The Planning Inspectorate

Our Ref: TR050006

Planning Act 2008 (as amended) – Section 51

Application by Roxhill (Junction 15) Limited for an Order Granting Development Consent for the Northampton Gateway Rail Freight Interchange

INSET (E) A508 Grafton Regis

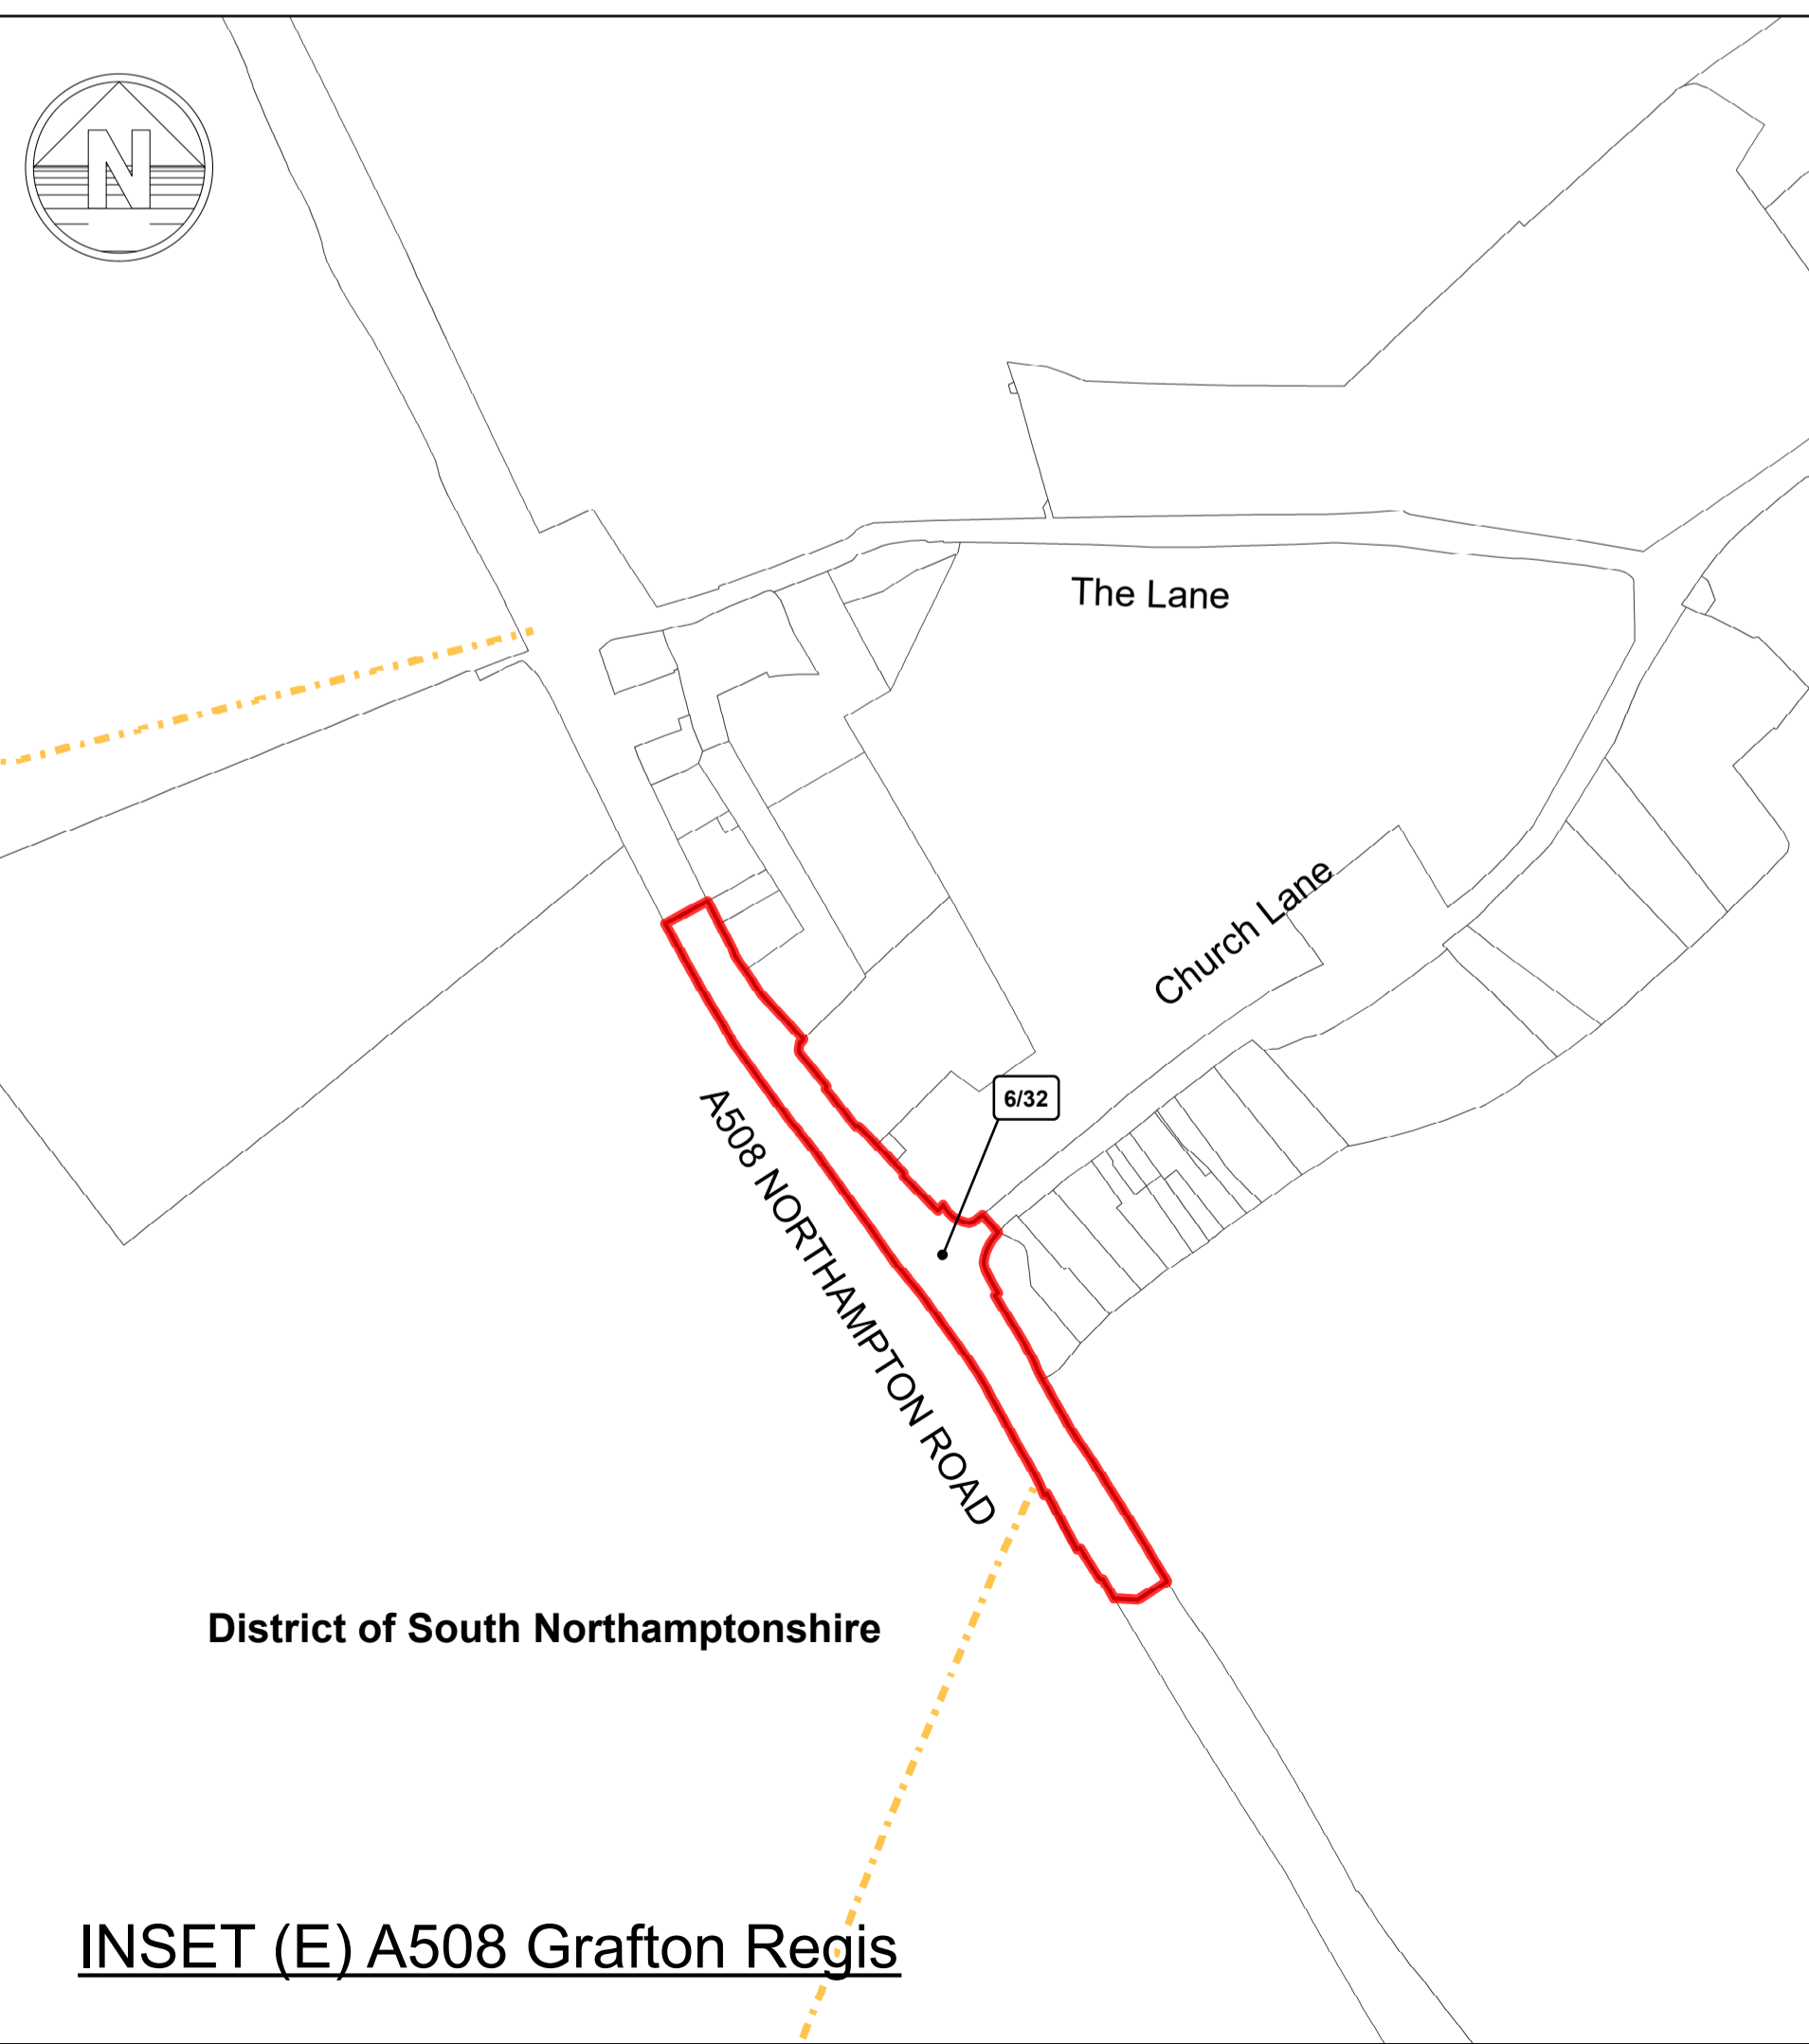
The following plots on the land plans cannot be seen clearly: 2/29, 6/8, 6/12, 6/15 & 6/16. On sheet 6 of the land plans the point at which plots 6/5, 6/6, 6/8 & 6/9 meet is unclear. The Applicant should consider providing updated plans.
